SUBJECT: Engineering Review Comment
Mountain View Electric Association Inc. (MVEA)

Project Name: Manley Subdivision Filing 2 – Minor Subdivision

Project Number: VR2310

Description: A partial replat of Lot 2 of Filing 1 located on the northwest corner of Curtis Rd. and Jones Rd. in Township 13S, Range 64W, Section 22.

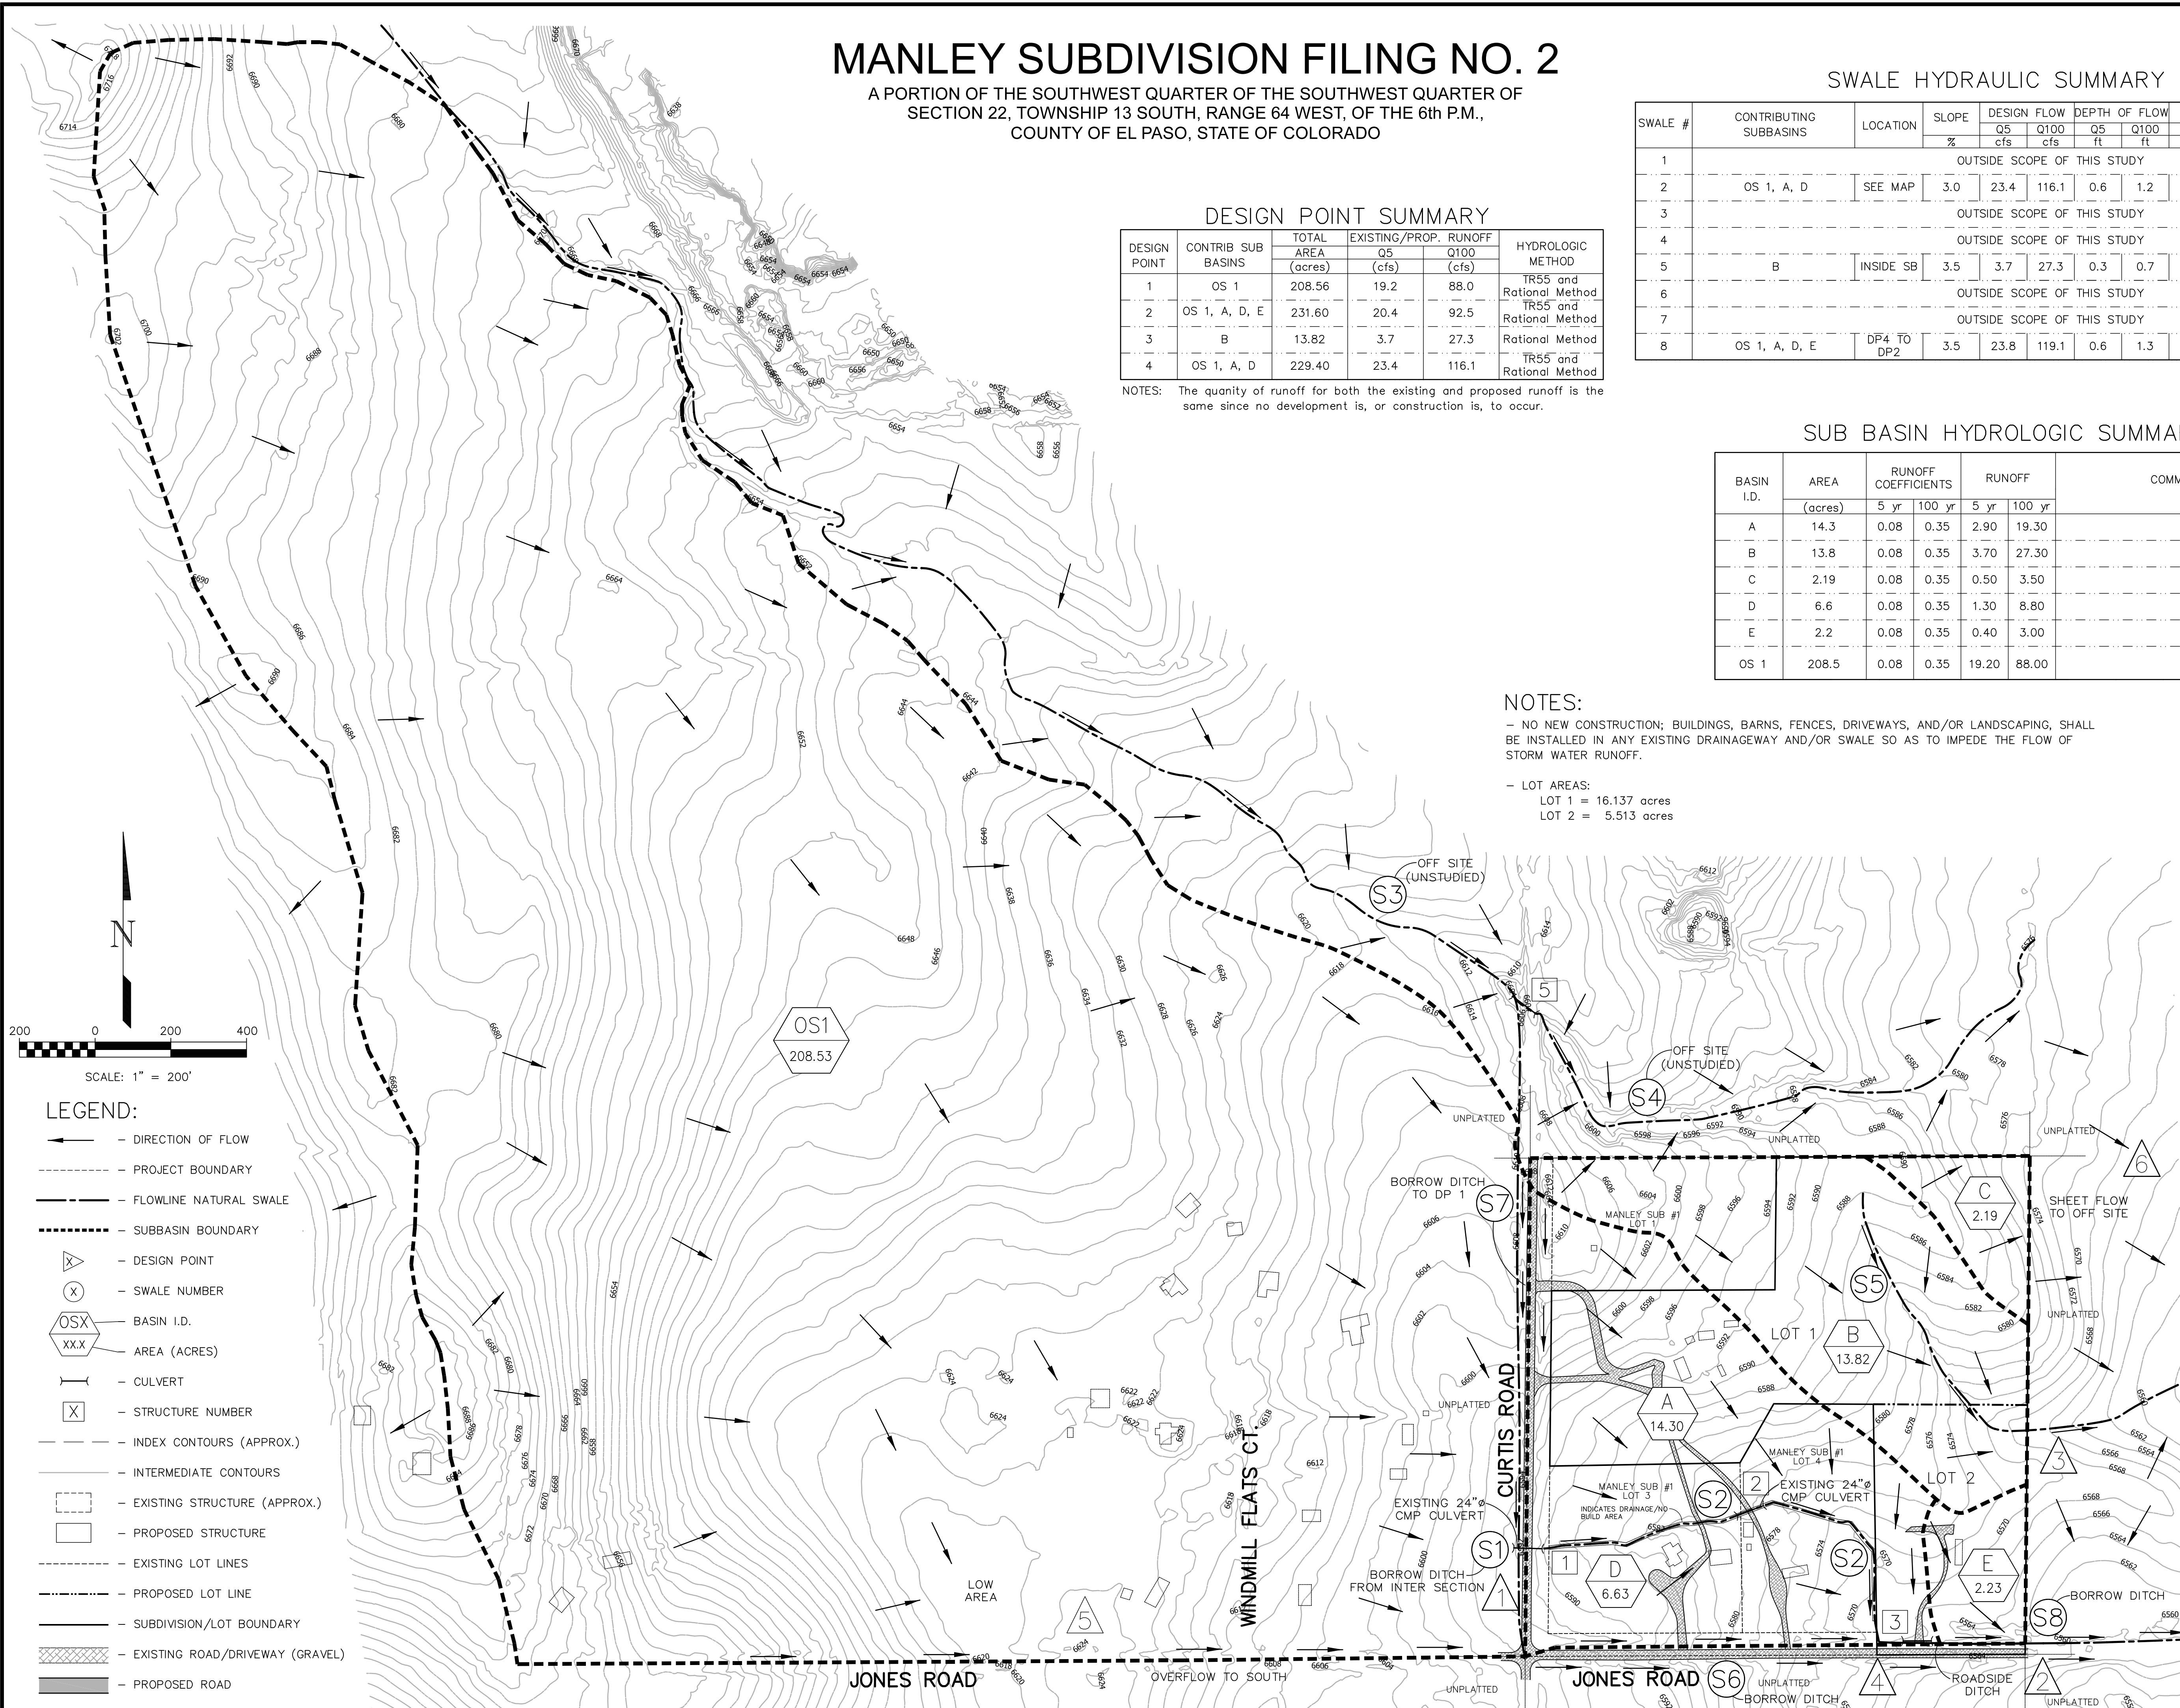
MVEA requests a ten (10) foot front, side, and rear lot utility easements and all tracts, along with a twenty (20) foot exterior utility easement on the plat. In addition, a ten (10) foot easement adjacent to all access easements. MVEA also requests the platting of MVEA's existing facilities with easements on the plat. Additional easements may be required.
